May 17, 2013

RE: **Zia Park Townhouse Apartments** – Zia Road NE
Grading & Drainage Plan for Grading and Building Permit
Tracts H & I, La Cuesta Subdivision

File **K22-D022D**
PE Stamp: 5/5/13

ENGINEER'S SEAL 	ZIA PARK HOMES GRADING AND DRAINAGE PLAN Rio Grande Engineering 1806 CENTRAL AVENUE SUITE 201 ALBUQUERQUE, NM 87106 (505) 872-0999 MAY 2013	DRAWN BY WCMJ DATE 5-07-13 2721-LAYOUT-2-05-13 SHEET # JOB # 2721
---------------------	--	---

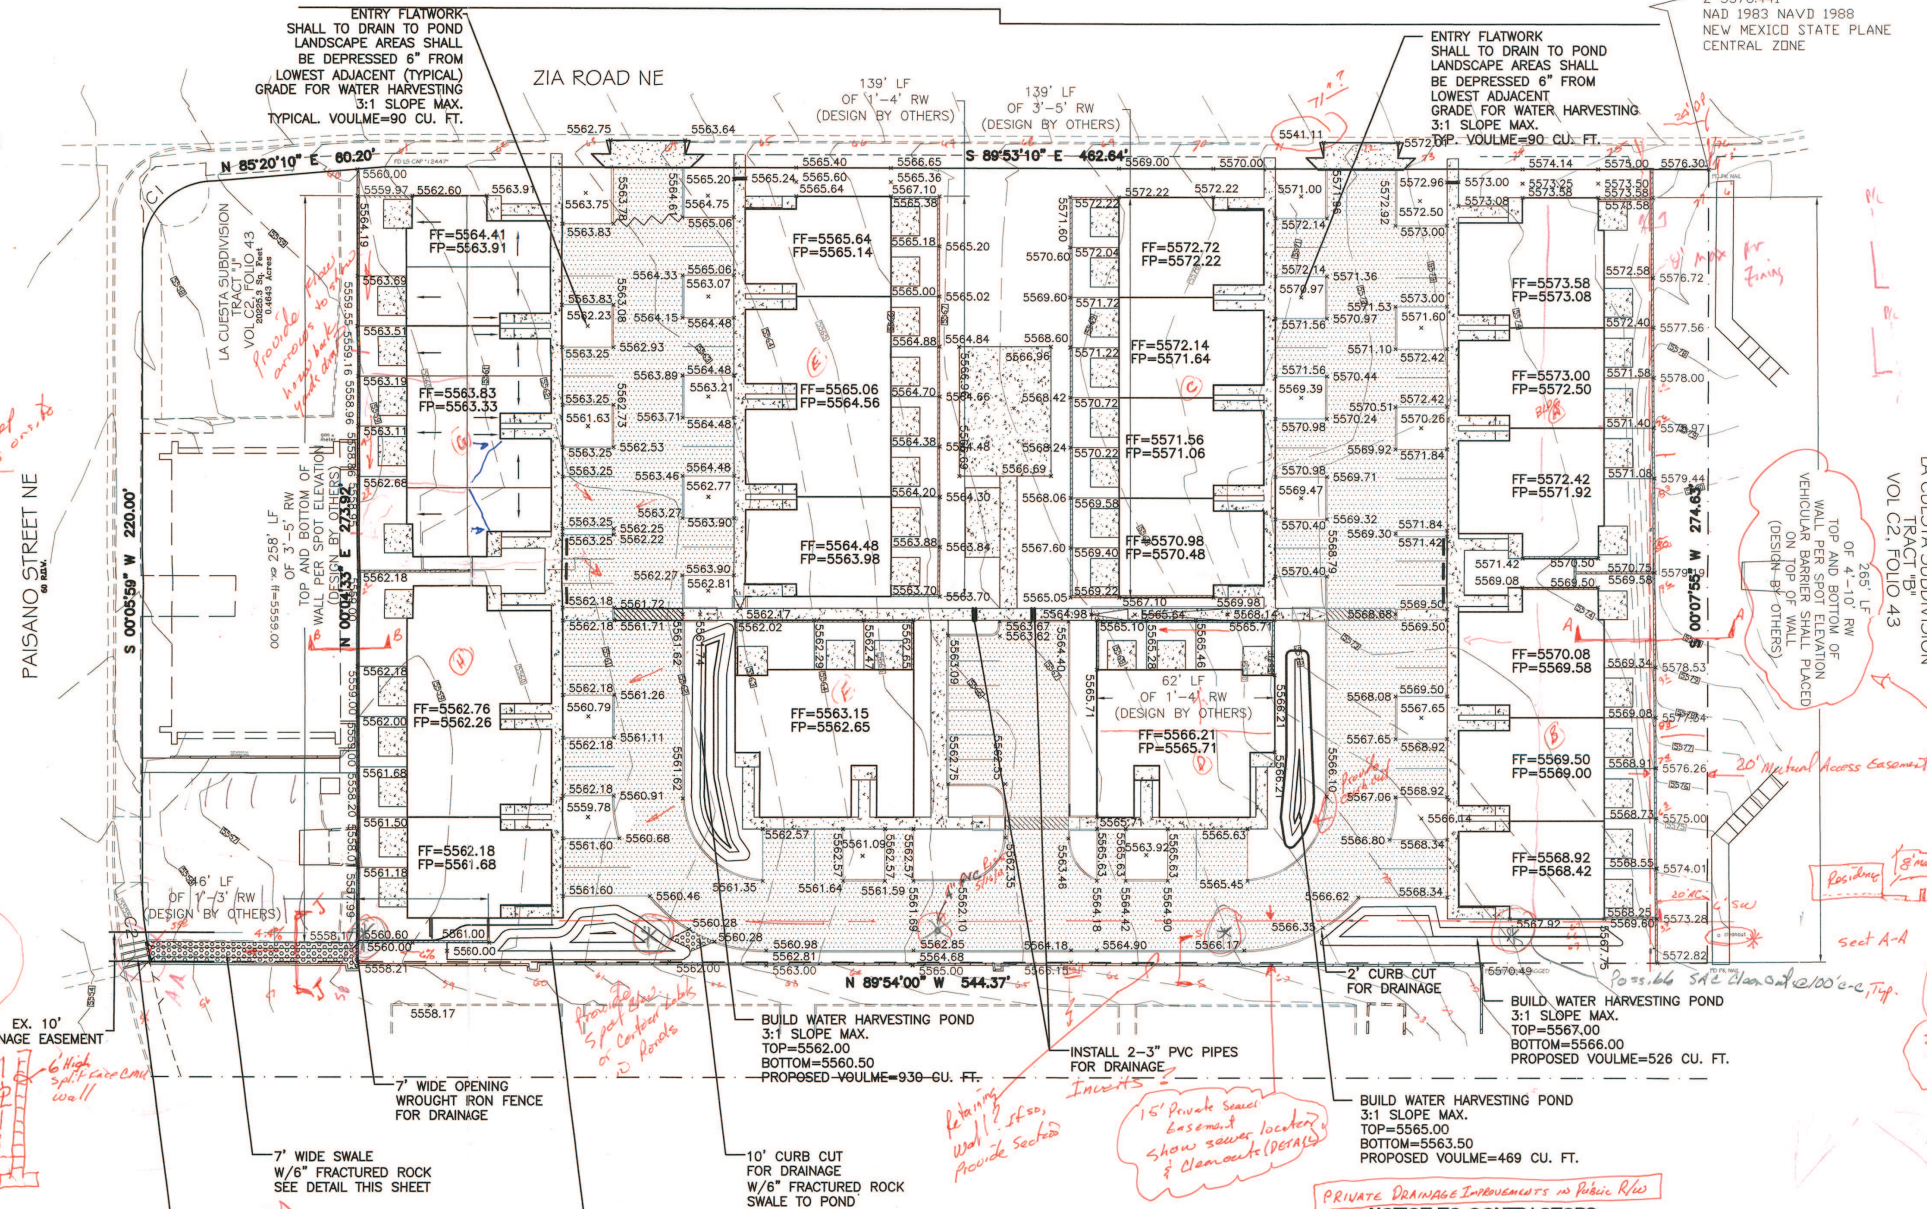
5. Clearly label or identify by Legend, all proposed structures and surface treatment conditions shown on your plan (e.g.- Pavement, Curbs, Landscape or turf areas, etc.). Clean up typo errors and errant information on the LEGEND.

6. Provide curb cuts to allow street flows to enter the two water quality/harvesting ponds on the north side of the “U” drive (SE of Bldg. D and SW of Bldg. F). Show with flow arrows, how the water is directed into or through these areas.

7. You indicated that the backyards are not intended to retain storm water runoff. Add some flow arrows to show how these areas will drain, with attention to the several locations where retaining walls are shown crossing the apparent flow path.

8. Provide a cross section at the west property boundary showing how the proposed retaining wall is to be built with existing block/wrought iron fence, to keep Zia Park, back yard and roof runoff from discharging onto Tract J.

9. Check the spot elevation of 5541.11 shown at the east entrance off Zia Road.
10. Per the Legend symbols, there is a retaining wall proposed along the south edge of the site. If so, provide a cross section of how it is to fit; if not, clarify the plan.

11. Regarding the existing paved roadway and proposed retaining wall along the eastern boundary of the site:
 - a. Show and label/dimension the “Mutual Access Easement.”

- b. Clarify the limits the existing and proposed pavement, and provide flow arrows for drainage patterns.
 - c. This plan shows a retaining wall, designed by others, separating the roadway from the new back yards, 4’ to 10’ lower. Although you may defer structural design details to others, this extreme situation of grade change adjacent to a traffic lane must be at least schematically addressed by this plan.

- i. What structural barrier will be required to keep vehicles out of yards, and will it affect runoff?
 - ii. Code restrictions on back yard wall heights (including traffic barriers and garden walls) will dictate terraced retaining walls on a portion of this boundary. Investigate and resolve for grading requirements.

- iii. Provide a typical Section through the retaining wall(s) and paving, extending to the east property line. This needs to show how drainage will be kept in the roadway, directed away from the retaining wall and yards below it.

12. Regarding the outfall channel at the SW corner of the site and crossing Tract J:
- The portion of channel on site has a slope of $\pm 6\%$. What erosion protection is required for this pond outfall channel?

- Provide a detail for the swale crossing of the security fence at the property line with Tract J. Consider flow capacity and security.
 - The 6" Fractured Rock Swale Detail is 7' wide, however site measurements revealed that the existing parking lot improvements on Tract J are approximately 6' from the southern property line, and the existing split faced block wall is over 6" south of the SW property corner (found plastic survey cap marked "Miers 12447").

- Provide a cross section of the Tract J swale, showing relative position of Rock Swale, adjacent paving and CMU wall, and detailing any revisions to the existing landscaping and parking lot improvements.

- The existing landscaping in the proposed drainage easement on Tract J includes four, 4' diameter Juniper shrubs, 2 Locust trees, and a very large (>20" dia.) Russian Olive tree. Will this landscaping all be removed, or will the channel capacity accommodate these obstructions?
